Mallard Pass Solar Farm

**Applicant's Response to Mallard Pass
Action Group Deadline 3 Submissions**

Deadline 4 - July 2023

EN010127/APP/9.34

Figure 2-1: Construction Compound Overview

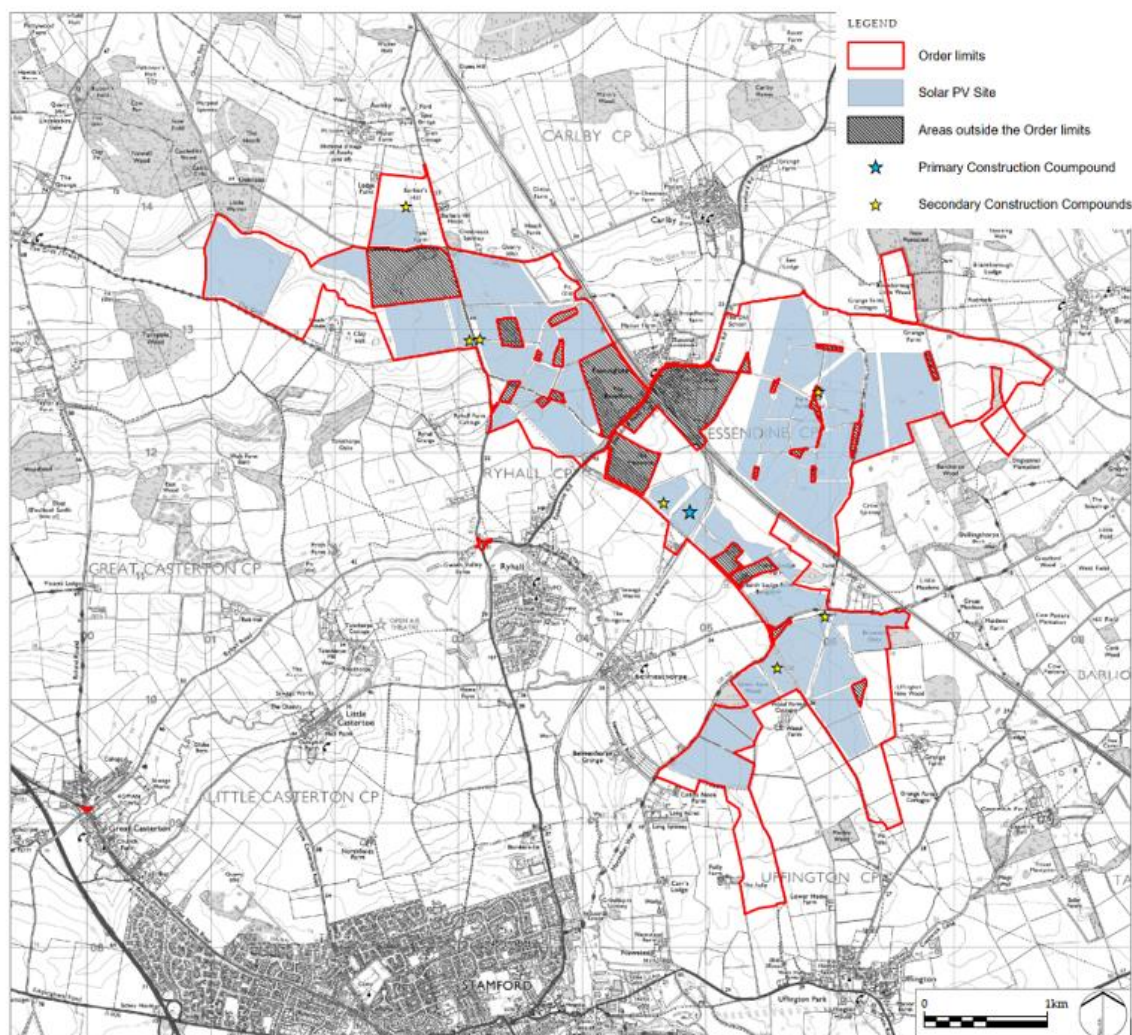
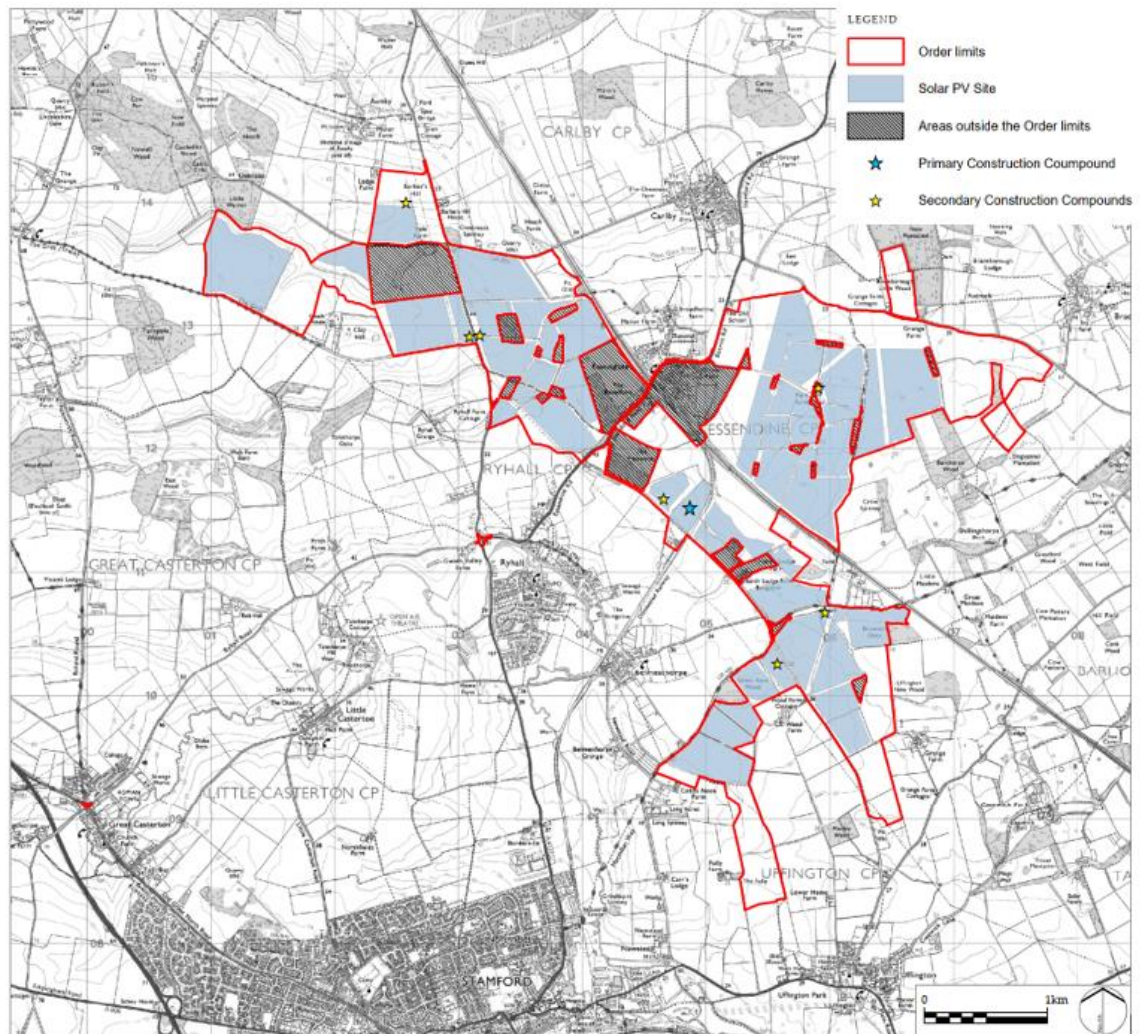
Q1.0.6	<p>Having viewed field 19 many times it does not seem feasible that it can be a primary construction compound, substation and car park for at least 150 cars, HGVs and LGVs, even if some are just there temporarily.</p>	<p>Field 19 is approximately 6.5ha, the Onsite Substation Compound is 2ha which leaves approximately 4.5ha for use at the primary construction compound. It should also be noted that Field 18 can also be used as a Temporary Construction Compound (Work No 5) as shown on the Works</p>

Plans [REP2-004], which will provide sufficient flexibility to accommodate the temporary uses as well as the Onsite Substation.
Q1.0.9	<p>The Applicant states “It is not considered appropriate to attempt to assess either the current or predicted future mental health status of residents living in the locality of the Order limits, as every person will have different subjective and objective reactions, thoughts, and feelings towards changes to, or influences upon, their environment, whatever those changes or influences may be caused by or attributed to.” The question refers to well-being as well as mental health. It is of course the case that the Applicant cannot assess the impact on the mental health of individuals. Presumably this was not the purpose of the question. However, the Applicant could have commented in the general sense on the likely impact of the proposed development on the well-being of residents and visitors. The Applicant chose not to do so, presumably because the Applicant could not conclusively demonstrate that the</p>	<p>The Applicant has assessed the impact of the Proposed Development on environmental factors relevant to wellbeing and mental health throughout the Environmental Statement. This includes the potential for the Proposed Development to affect health outcomes through changes in the following factors:</p> <ul style="list-style-type: none"> • Recreation and amenity – these impacts are addressed in ES Chapter 6 Landscape and Visual [APP-036]. This chapter explains the extent of large-scale visual effects as follows: “<i>The extent of Large scale visual effects, where the Proposed Development would form a major alteration to key elements, features, qualities and characteristics of the view such that the baseline will be fundamentally changed, would generally be limited to locations within or immediately surrounding the Solar PV Site and Onsite Substation.</i>” In this way, some significant adverse impacts are identified within the hyper-locality of the site. • The plans submitted for Deadline 3 at Appendix B [REP3-037] illustrate the network of PROW within the locality and their spatial relationship to the Proposed Development and indicate a
